## PLAN CORRECTIONS REPORT PL-000207-2018 FOR CITY OF PORTLAND

**PLAN ADDRESS:** 222 Saint John St  
Portland, ME 04102  
**PARCEL:** 064 A002001

**APPLICATION DATE:** 06/20/2018  
**SQUARE FEET:** 0.00  
**DESCRIPTION:** Construction of 2,400 space parking structure (ground level plus 8 tiers) plus 52 surface parking spaces and associated site improvements.

TYPICAL HYDRANT ASSEMBLY DETAIL
N.T.S.

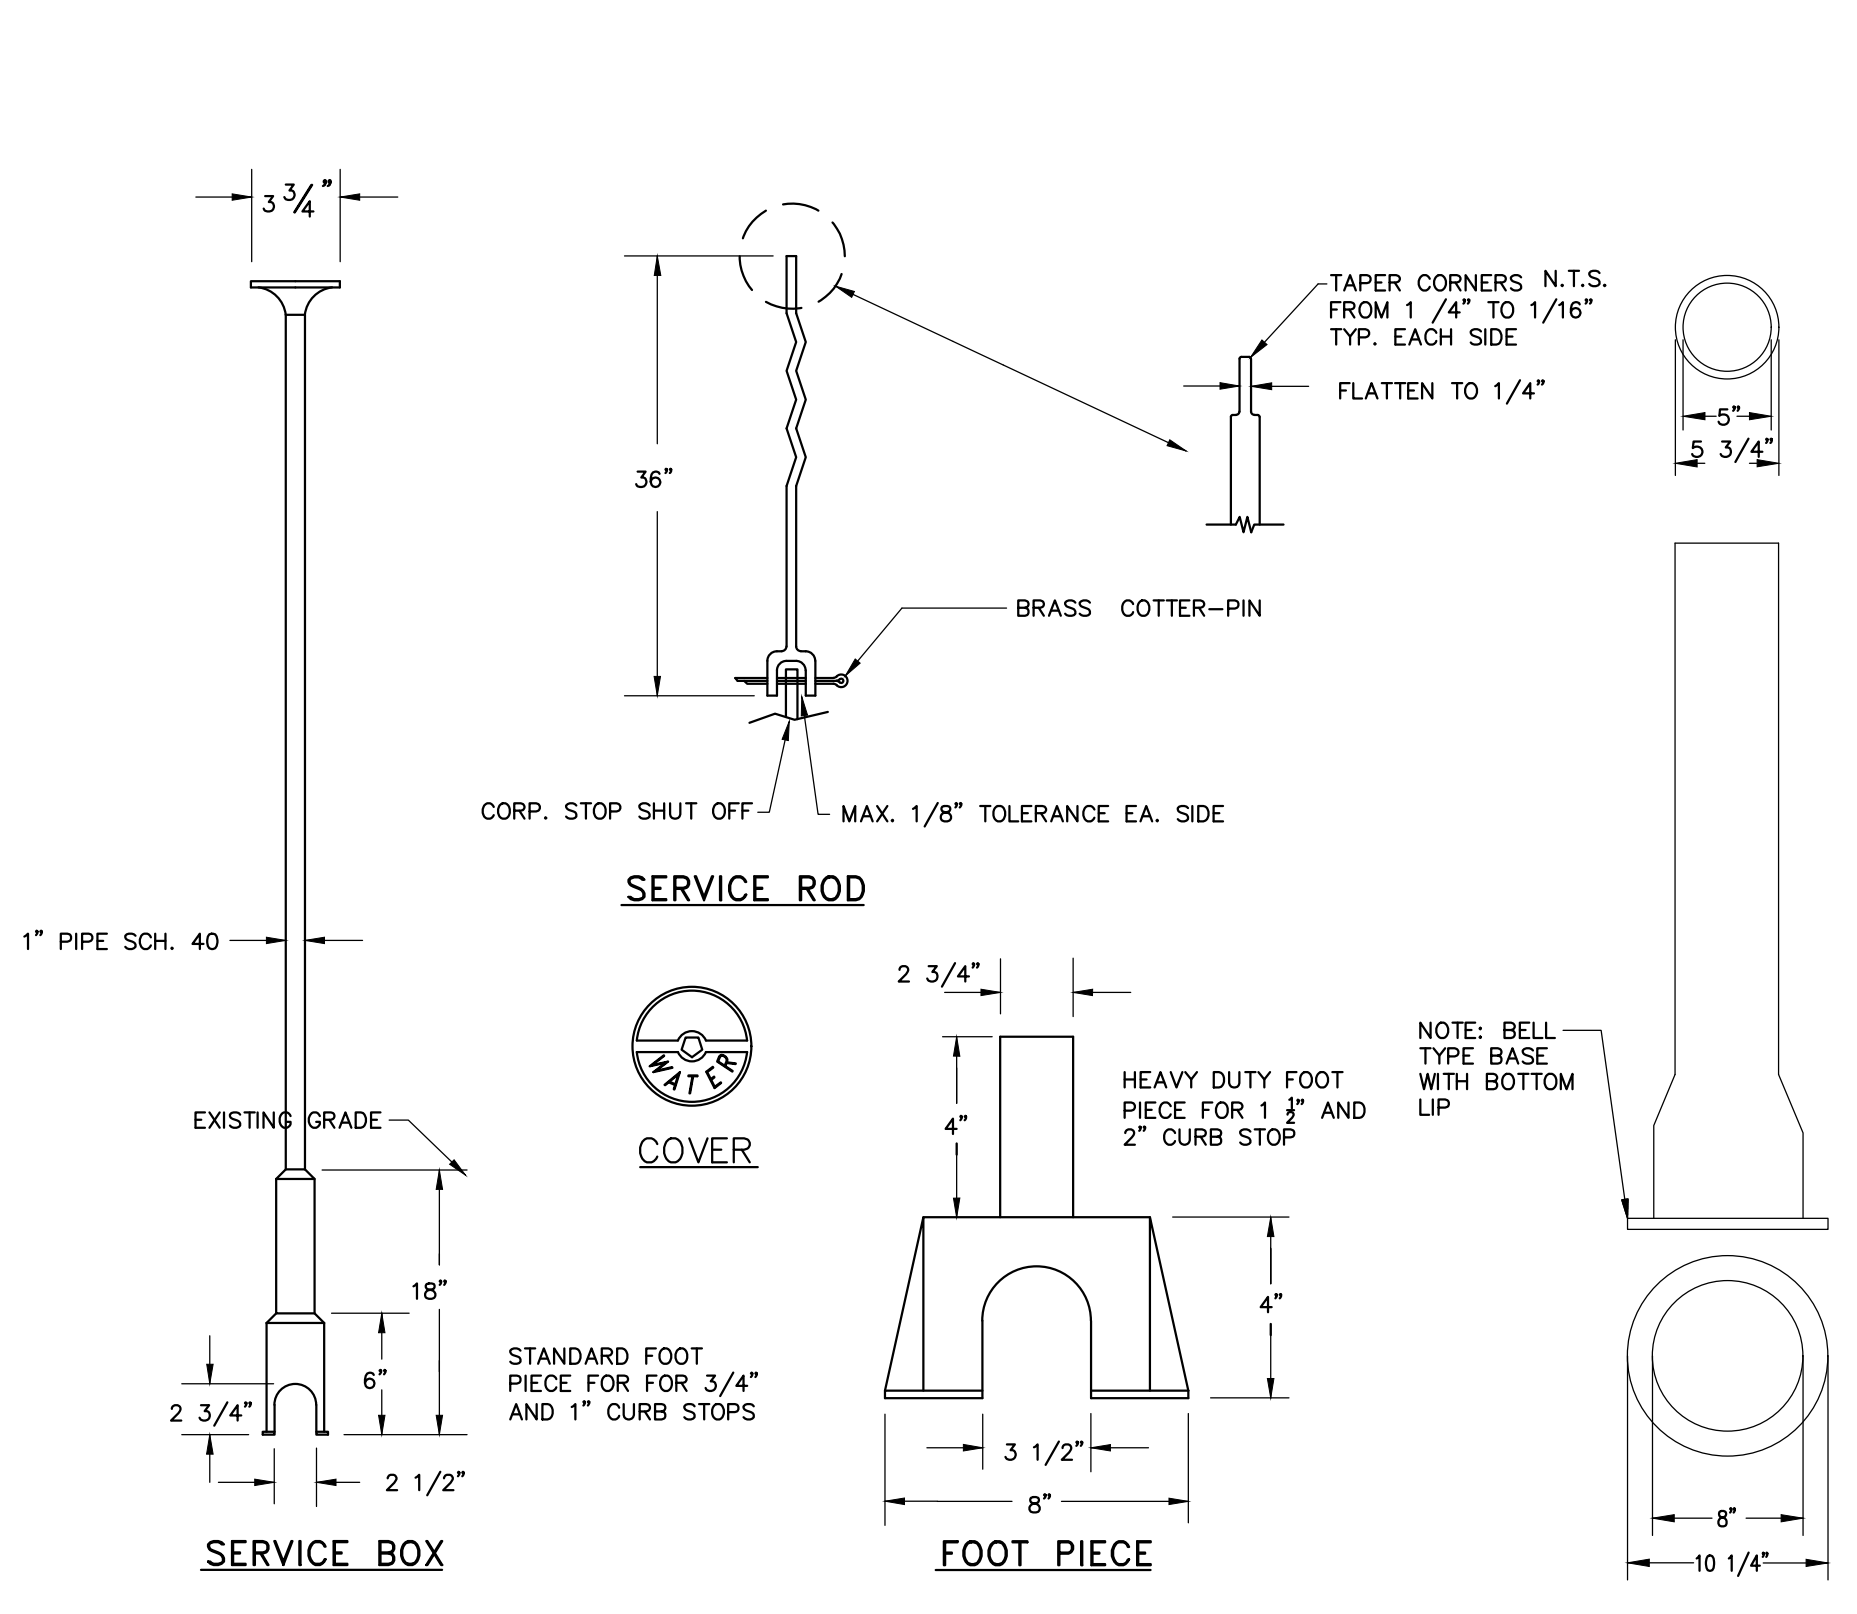
A private fire hydrant will be required along the right side of the building, accessible from the lower parking lot.
